September 22, 2016

SUBJECT: Response to August 23, 2016 Review of NCDOT's application for Section 404 and 401 permits for the proposed improvements to NC 3 (Mooresville Road), from Kannapolis Parkway to Dale Earnhardt Boulevard/Loop Road (SR 1691), Cabarrus County, North Carolina. Tip No. U-3440.

Reference: NCDWR On-Hold letter, dated August 23, 2016
NCDOT 404 & 401 Application dated June 16, 2016

PROJECT REFERENCE NO. U-3440	SHEET NO. 5
RW SHEET NO.	
ROADWAY DESIGN ENGINEER	HYDRAULICS ENGINEER
DOCUMENT NOT CONSIDERED FINAL UNLESS ALL SIGNATURES COMPLETED

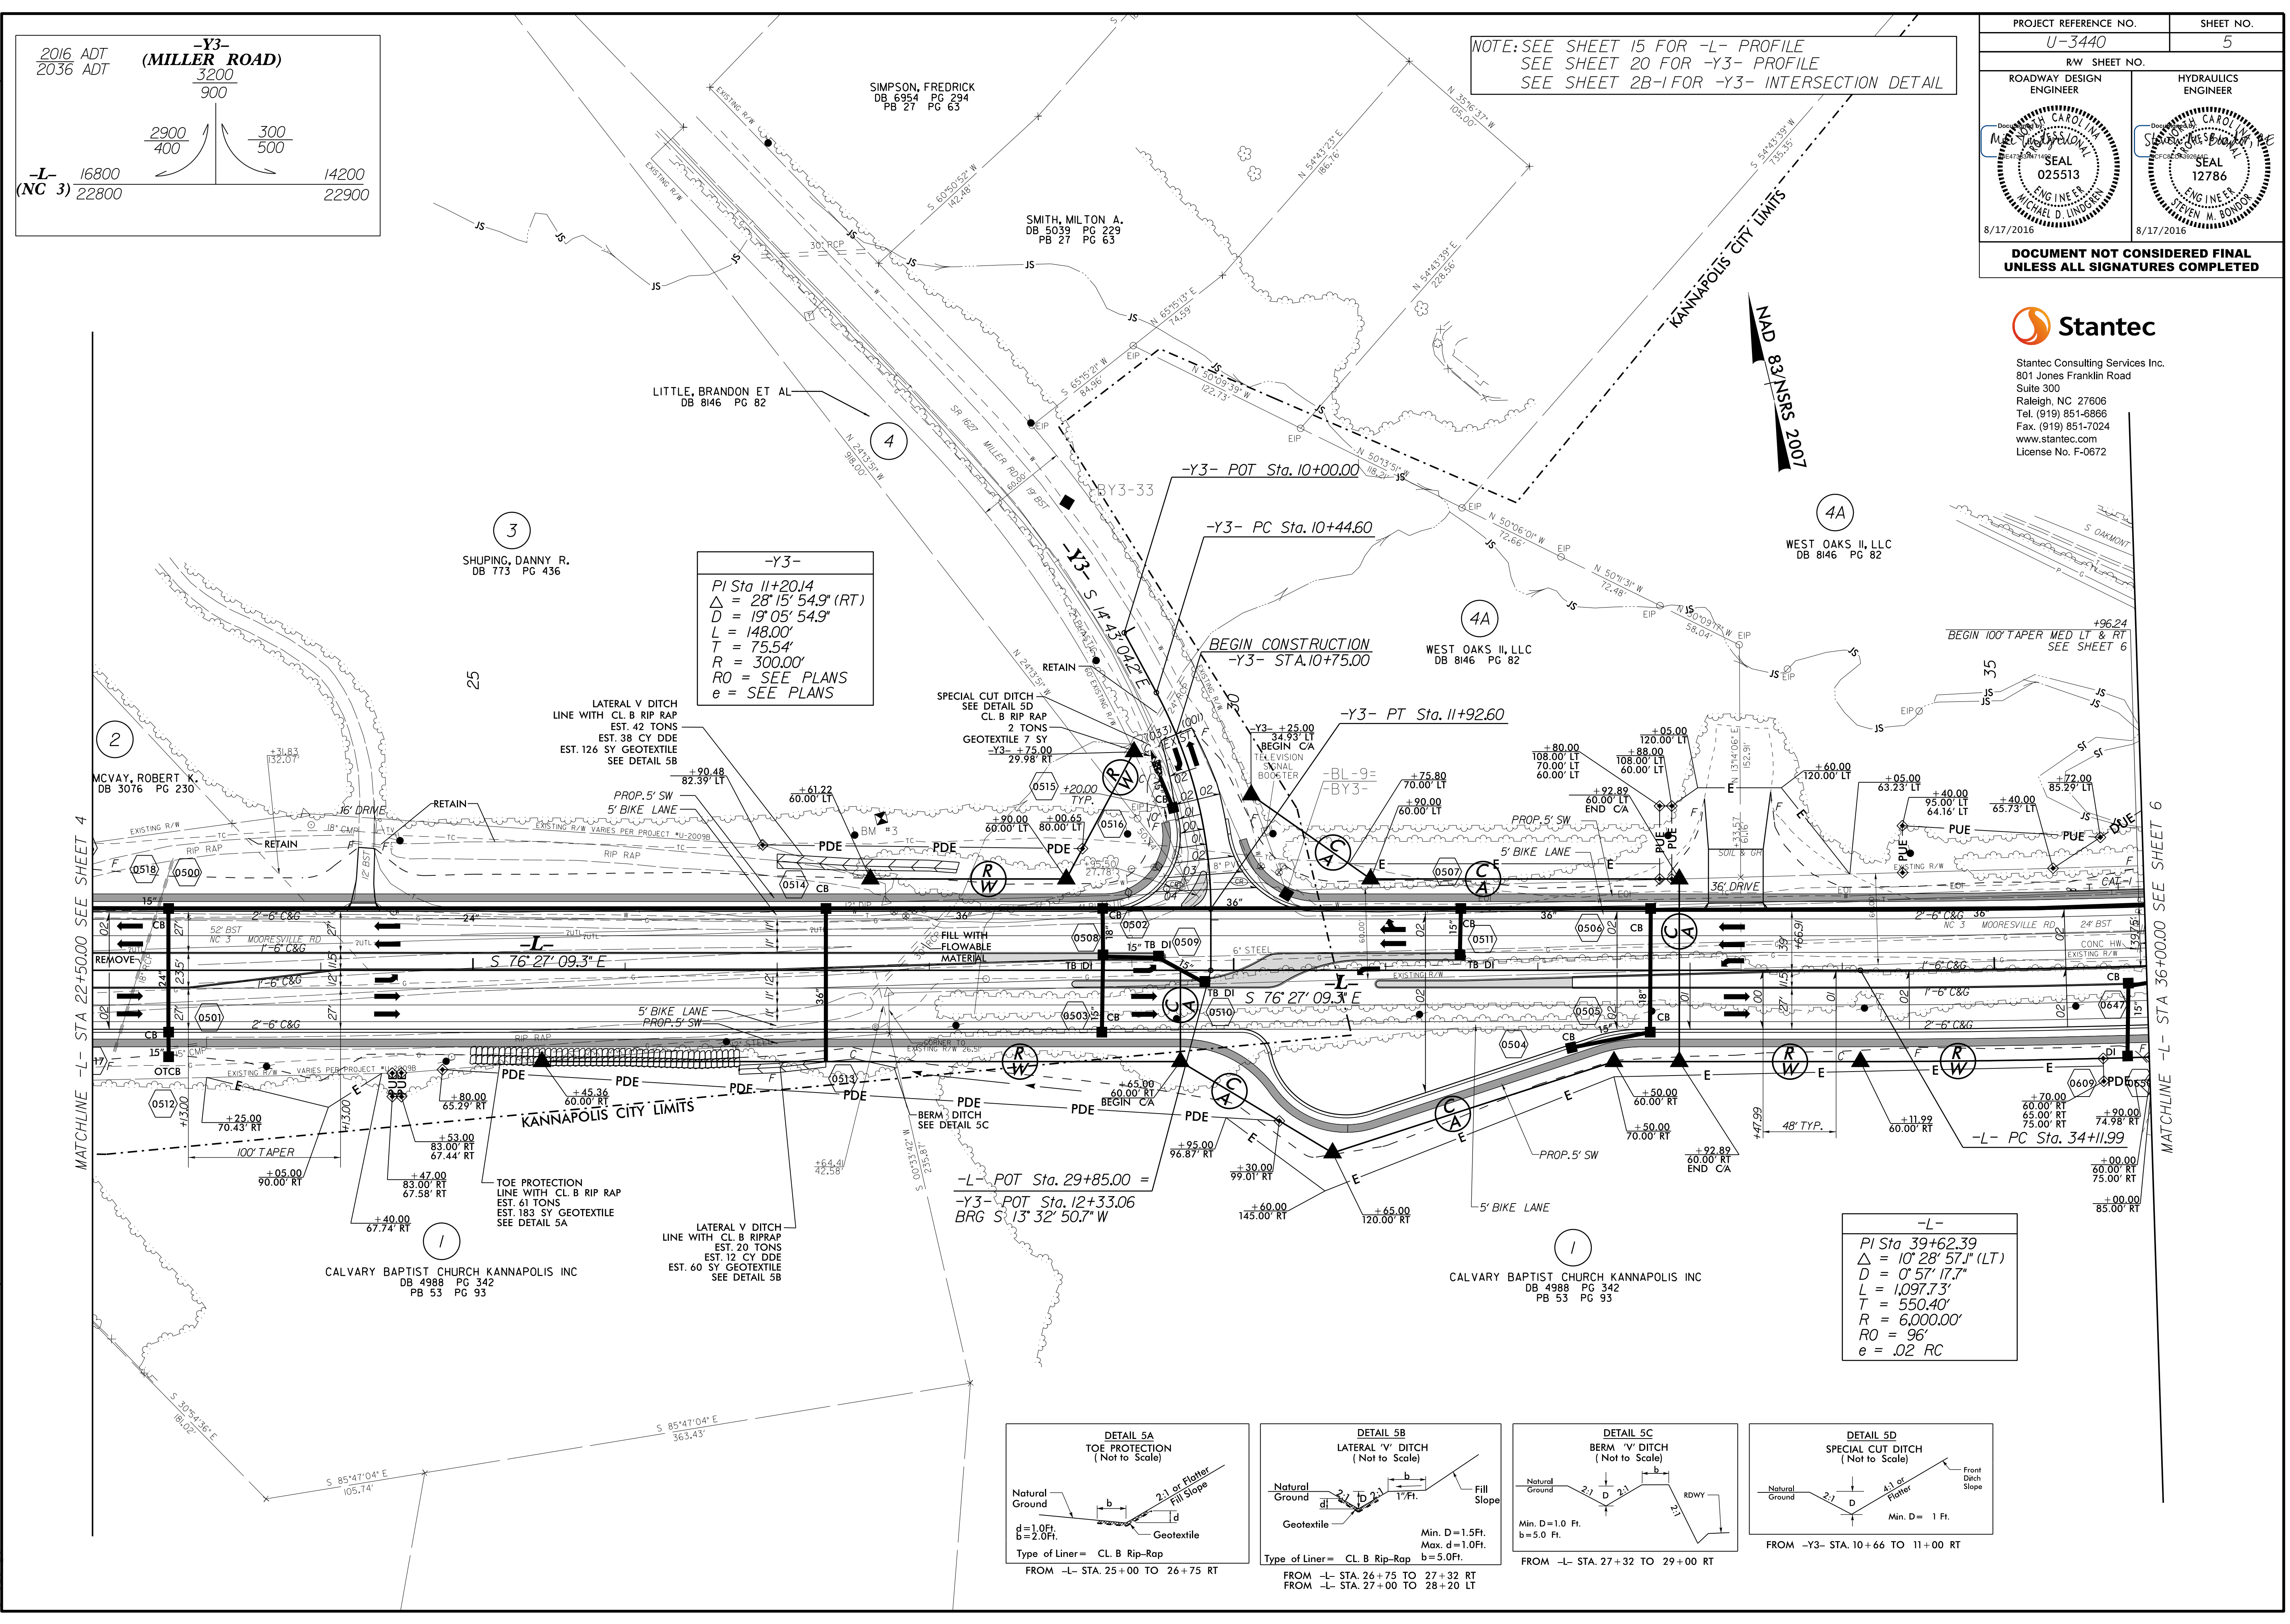
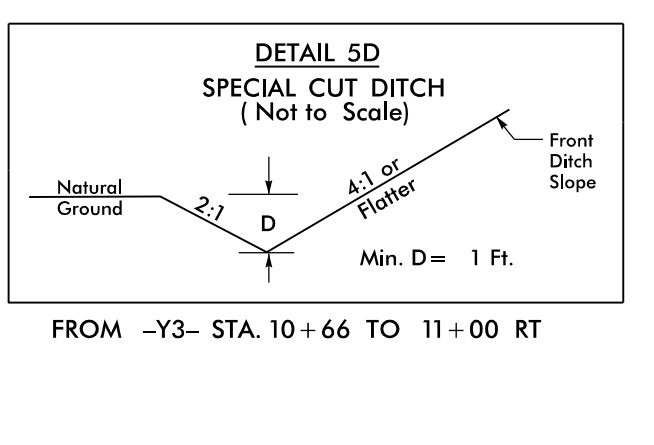
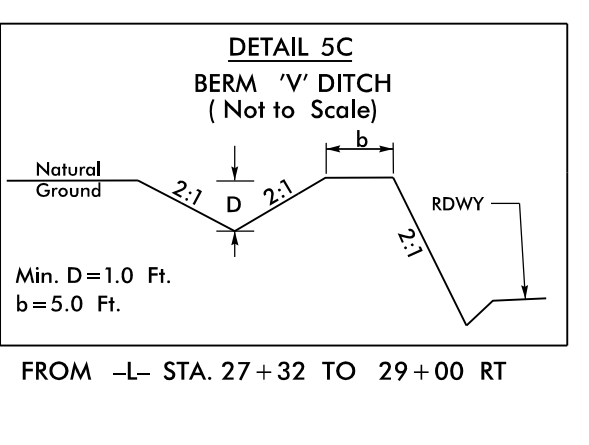
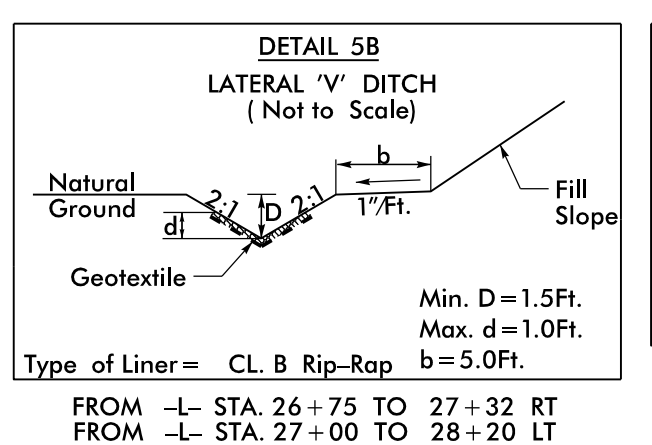
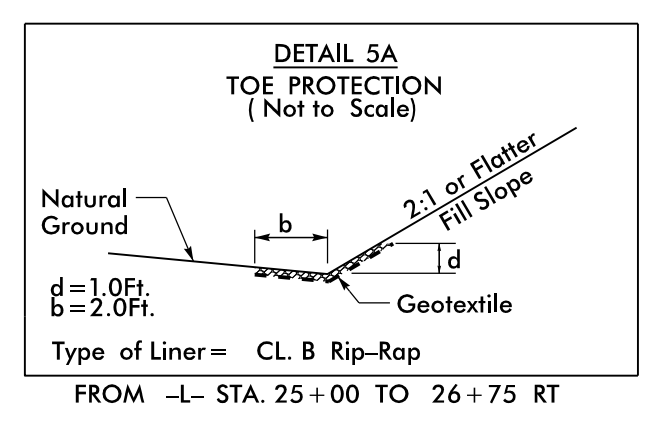
- NCDWR Comment: Existing stream profiles for all relocated and realigned streams are needed.
 - NCDOT Response: Ditch profiles have been included in the revised permit drawings for areas where streams will be realigned.
- NCDWR Comment: There is no detail for stream reconstruction at the end of the 10X9 culvert near Site MB.
 - NCDOT Response: Detail 6D has been added to the revised permit drawings to address this.
- NCDWR Comment: PSRM is listed as a liner in the bed of a relocated jurisdictional stream at Site S1. This is a permanent impact that was not agreed upon in previous merger meetings.
 - NCDOT Response: PSRM has been removed. Based on stream grade, Class B riprap armoring is needed and has been included in Detail 6A.
